Your Ref: 000014171
Our Ref: AB/121/12/L 08-10-2012
Please ask for:
Mrs A Gardner

Application for listed building consent for 1 No new dwelling
Land adjacent to 84 Maltravers Street Arundel

Thank you for your internet representation made on 7th December 2012 which has been recorded as '**an objection**' with the comments as follows:

Elevations & Section

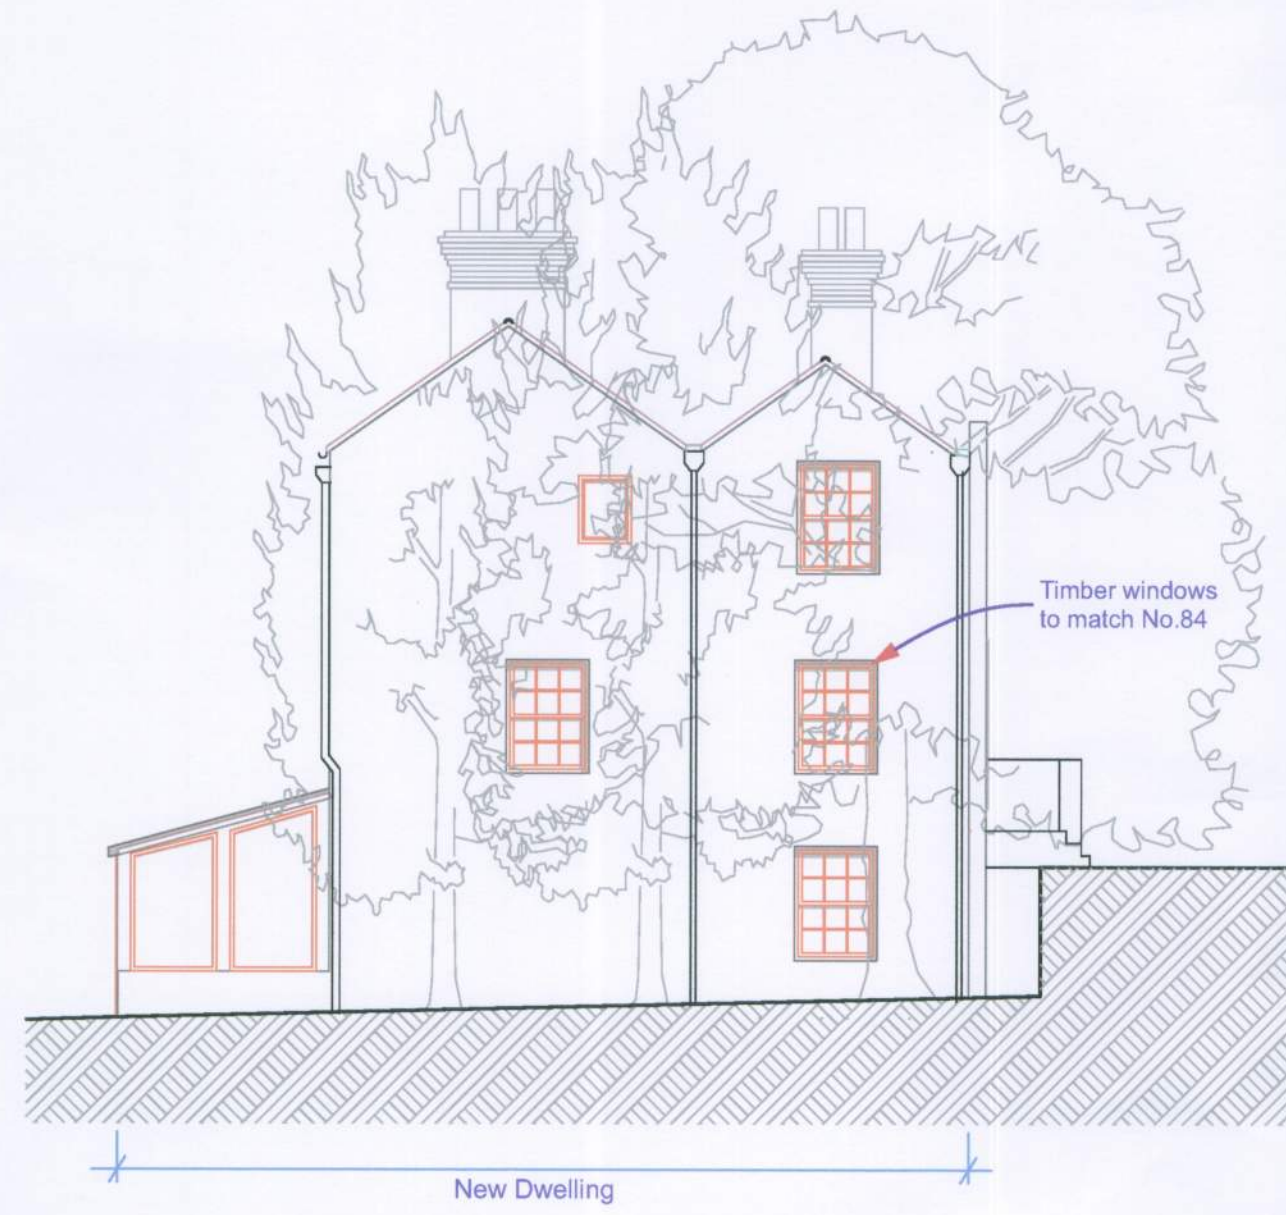
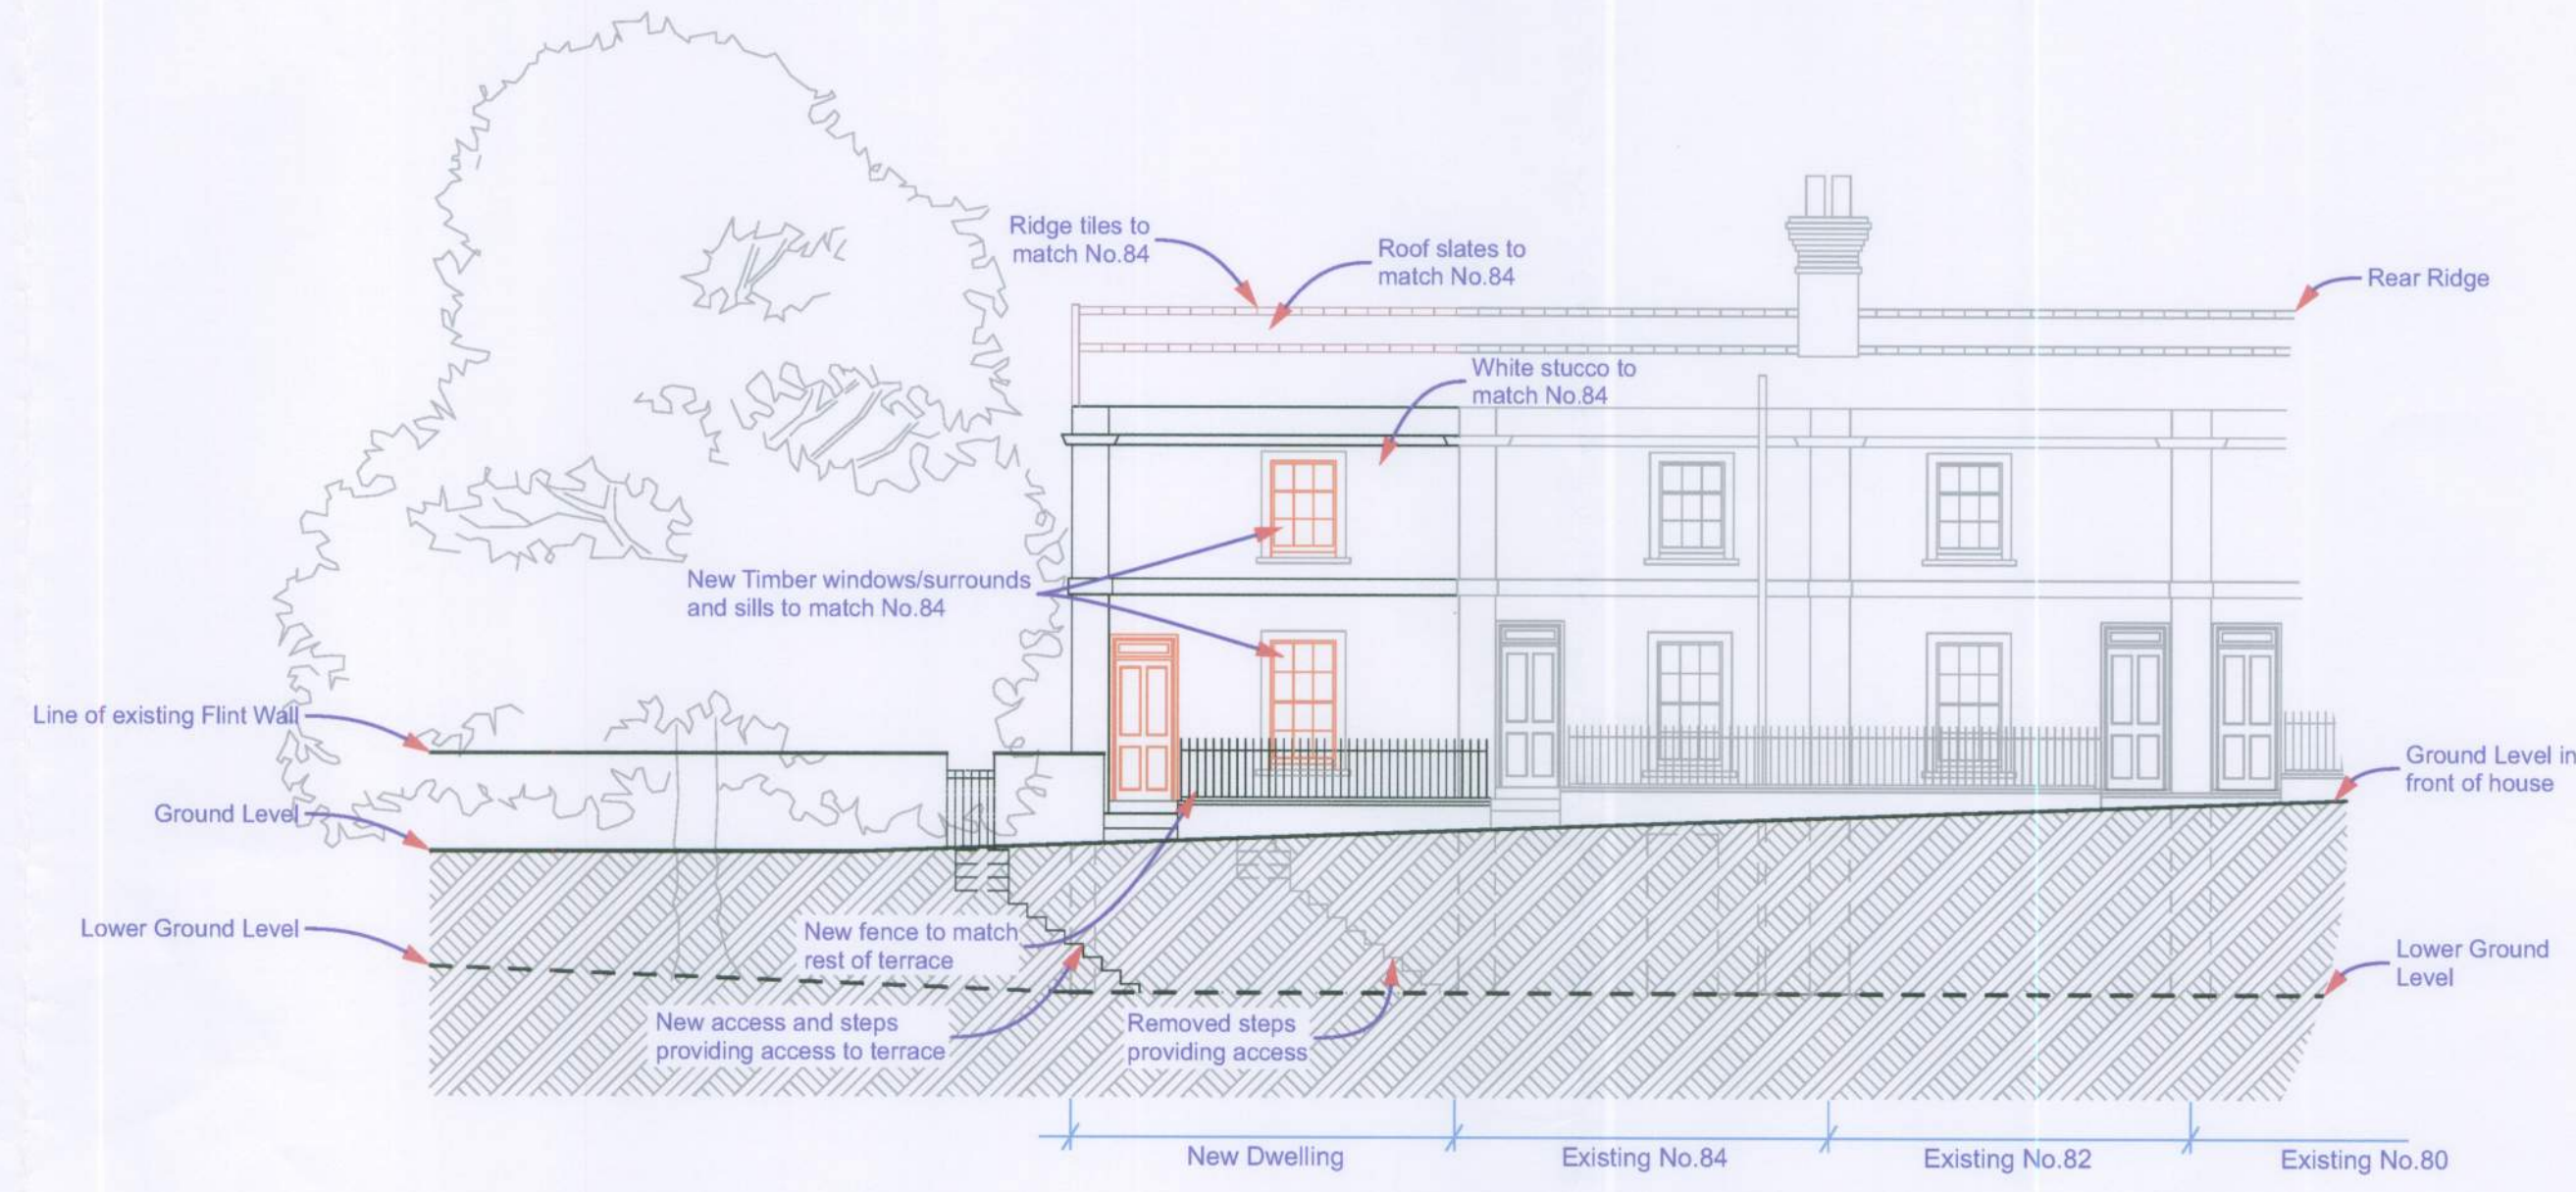
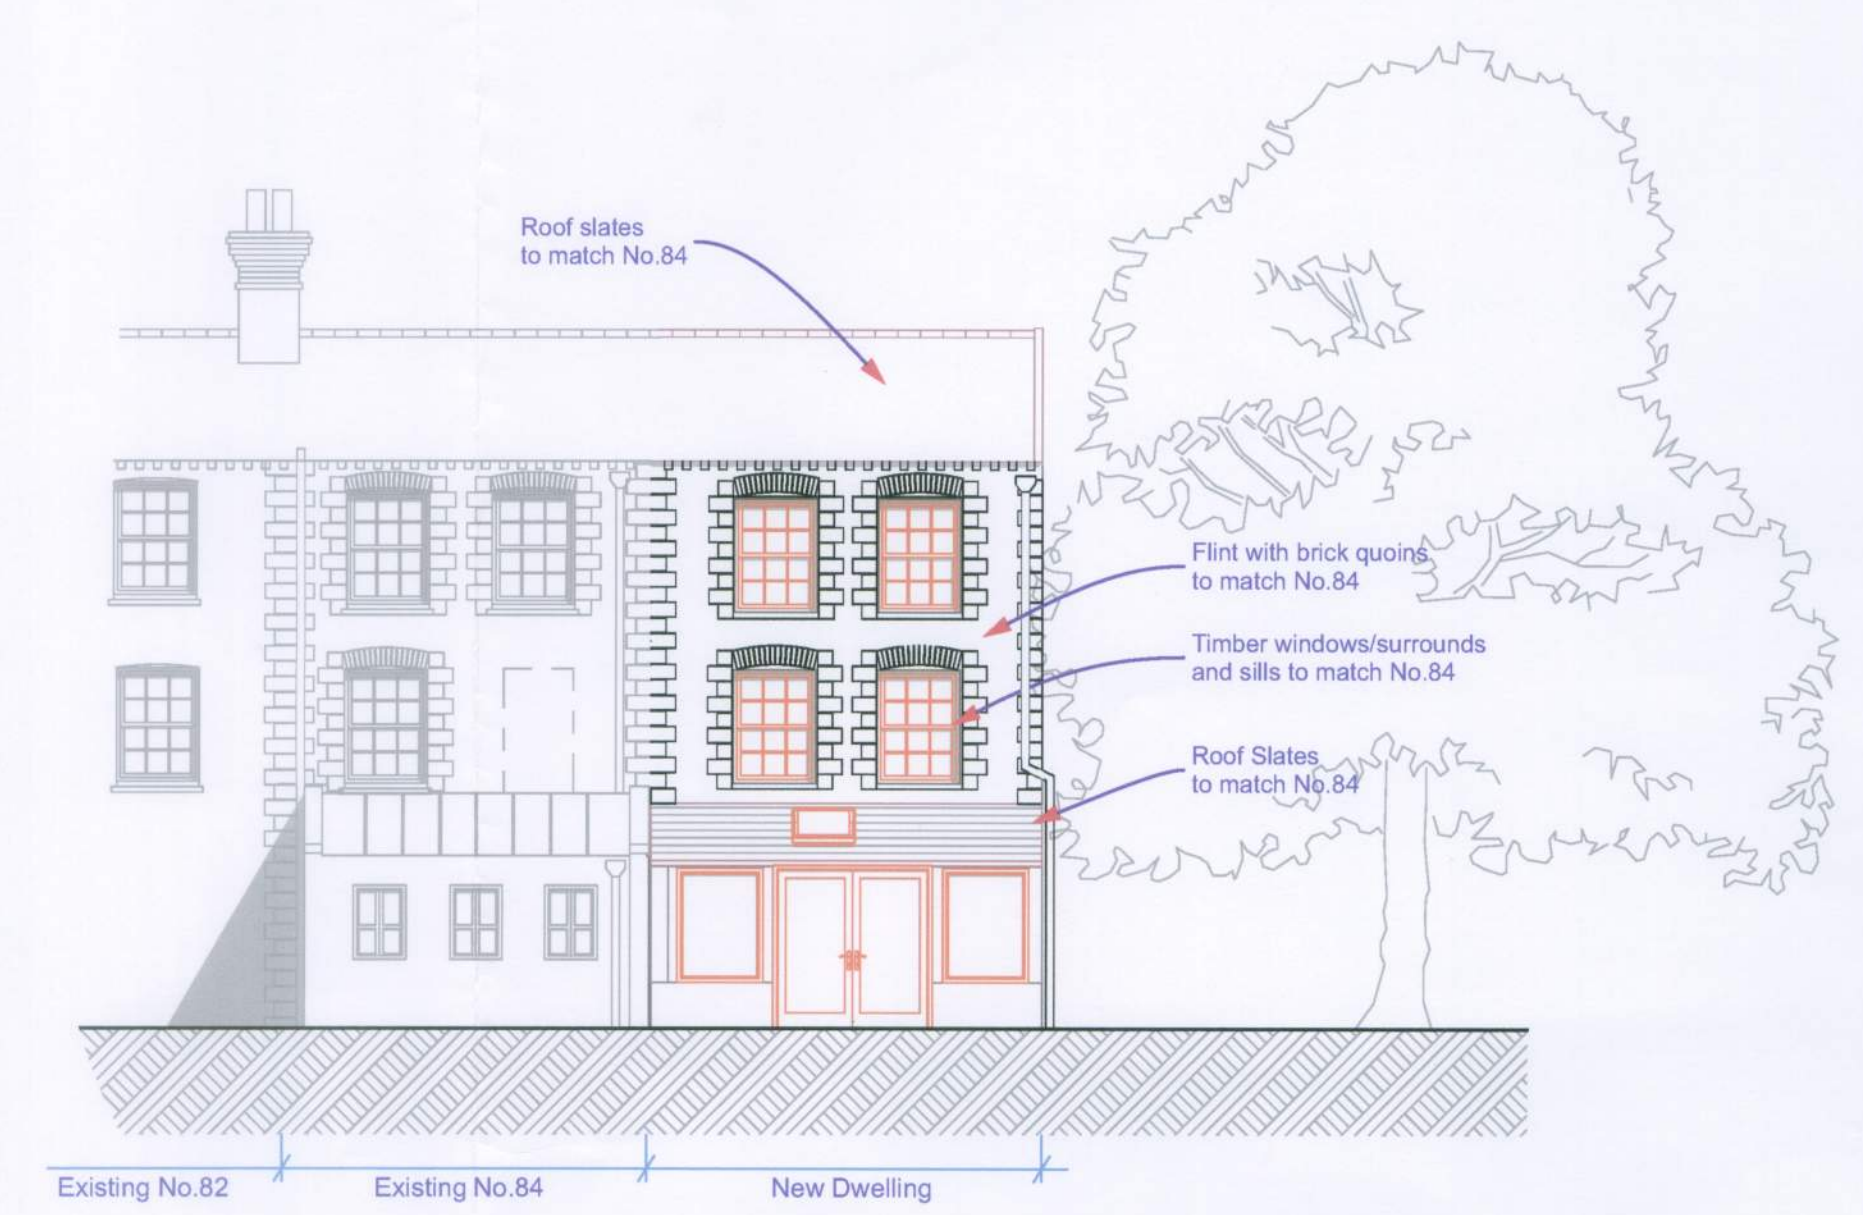
The Committee objected to the application on the grounds that the proposal still failed to sympathetically replicate the rhythm and important characteristics (height and location of the door; chimney and height of railings) of its neighbours and, as such, it would appear as an incongruous addition to what is otherwise a uniform and regular terrace of listed properties. It would therefore detract both from the character and appearance of the row of properties and its prominent and important setting at one of the main entrances into the Town of Arundel.
